Appeal Decision

Appeal Ref: APP/C3105/Y/20/3251498

Cedar Lodge, North Side, Steeple Aston OX25 4SE

- The appeal is made under section 20 of the Planning (Listed Buildings and Conservation Areas) Act 1990 against a refusal to grant listed building consent.
 - The appeal is made by Mr & Mrs A Pasteur against the decision of Cherwell District Council.
 - The application Ref 19/02465/LB, dated 4 November 2019, was refused by notice dated 27 January 2020.
 - The works proposed are creation of a jib door and associated stair.
-

PART PLAN SHOWING JIB DOOR INTERVENTION 1:20

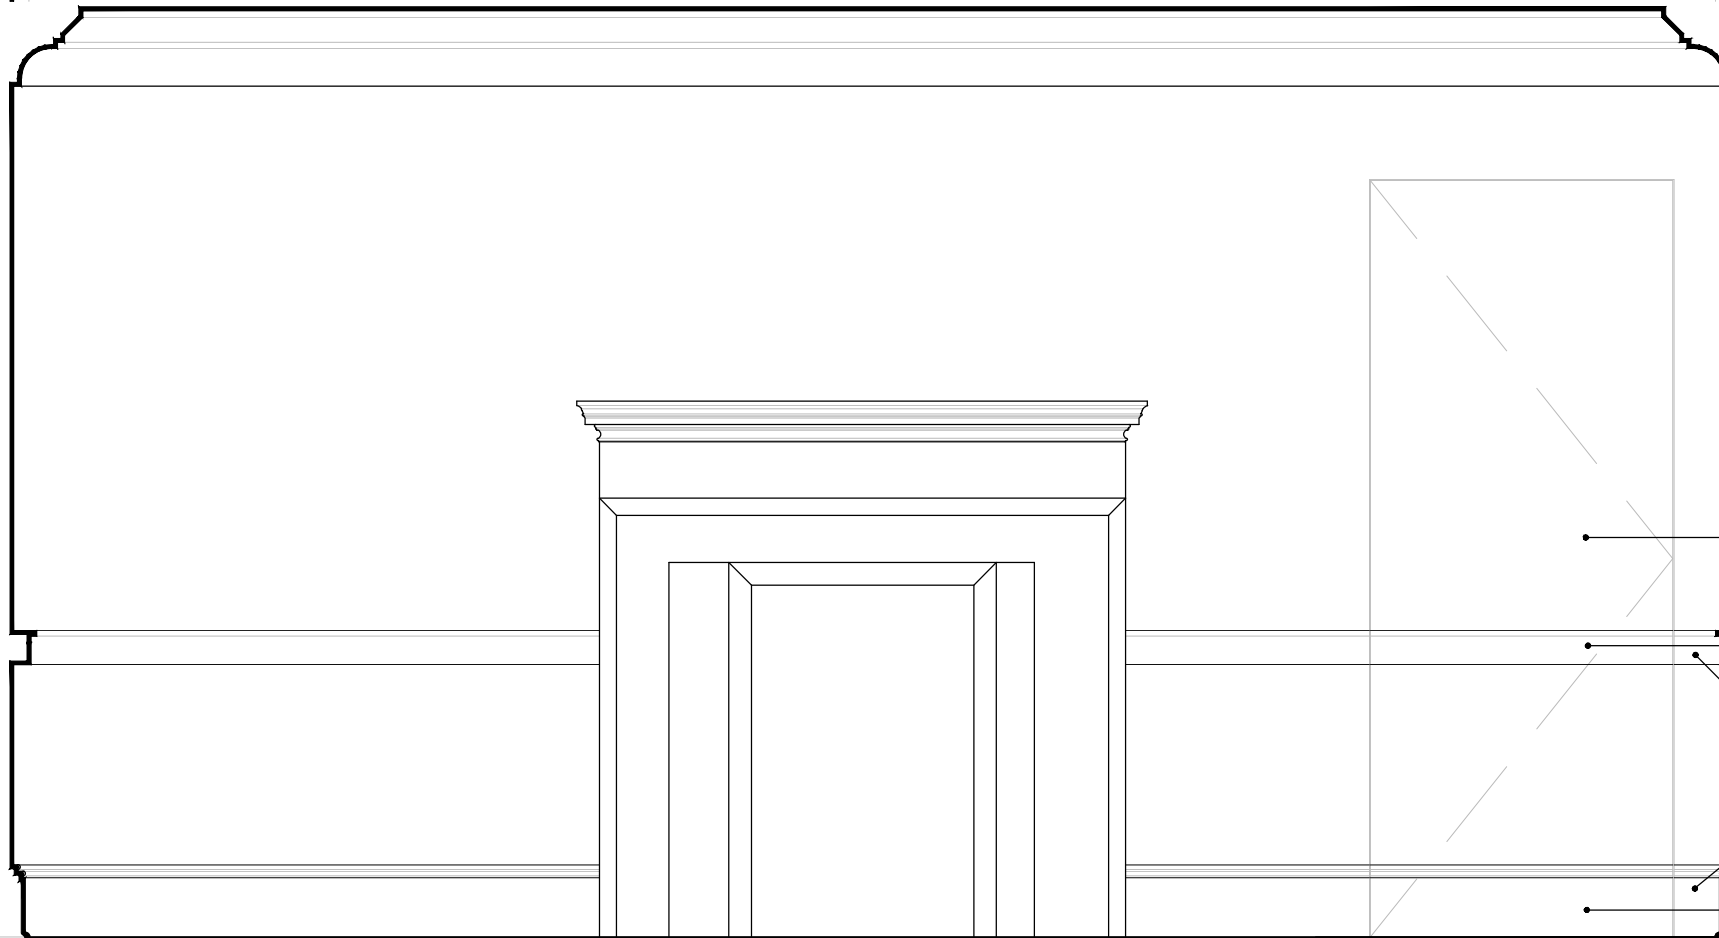
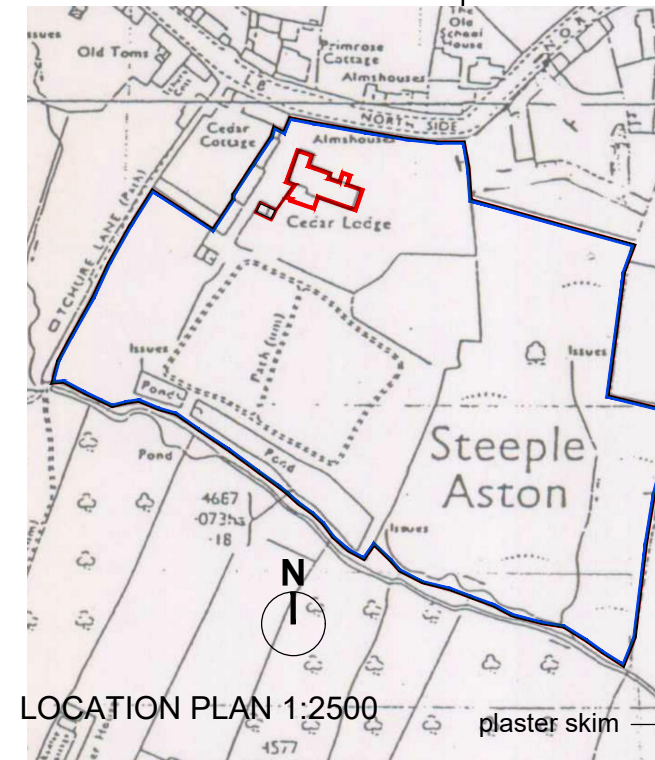
7. The proposal is to construct a jib door opening between a bedroom in the 'principal house' and a dressing area/study in the 'service wing'. The change in levels between the two elements of the building means that a staircase and 'top hat ceiling' would also need to be constructed in the dressing area/study.

10. Unlike the existing first floor link which is along a hallway and where floor levels are very similar, the proposed jib door opening would directly link two rooms from clearly distinct elements of the building. It would require a significant amount of alteration to accommodate the change in levels between these two rooms including an increase in the ceiling height within the smaller room. Consequently, the proposal would substantially erode the physical and historical functional separation between the two elements of the building and would alter its historic plan form. The proposed changes would mean that the social function of the building's spaces and their physical separation, an aspect that contributes to its special interest and significance, would be obscured, which would impair understanding and appreciation of the building's historic evolution and use.

11. In addition, it would result in the loss of historic fabric through the removal of walling and potentially through the removal of an area of lath and plaster ceiling and a number of ceiling joists, though it is unclear from the evidence whether the ceiling and ceiling joists are historic or more recent additions. At the time of my visit the ceiling within the dressing area/study was intact and
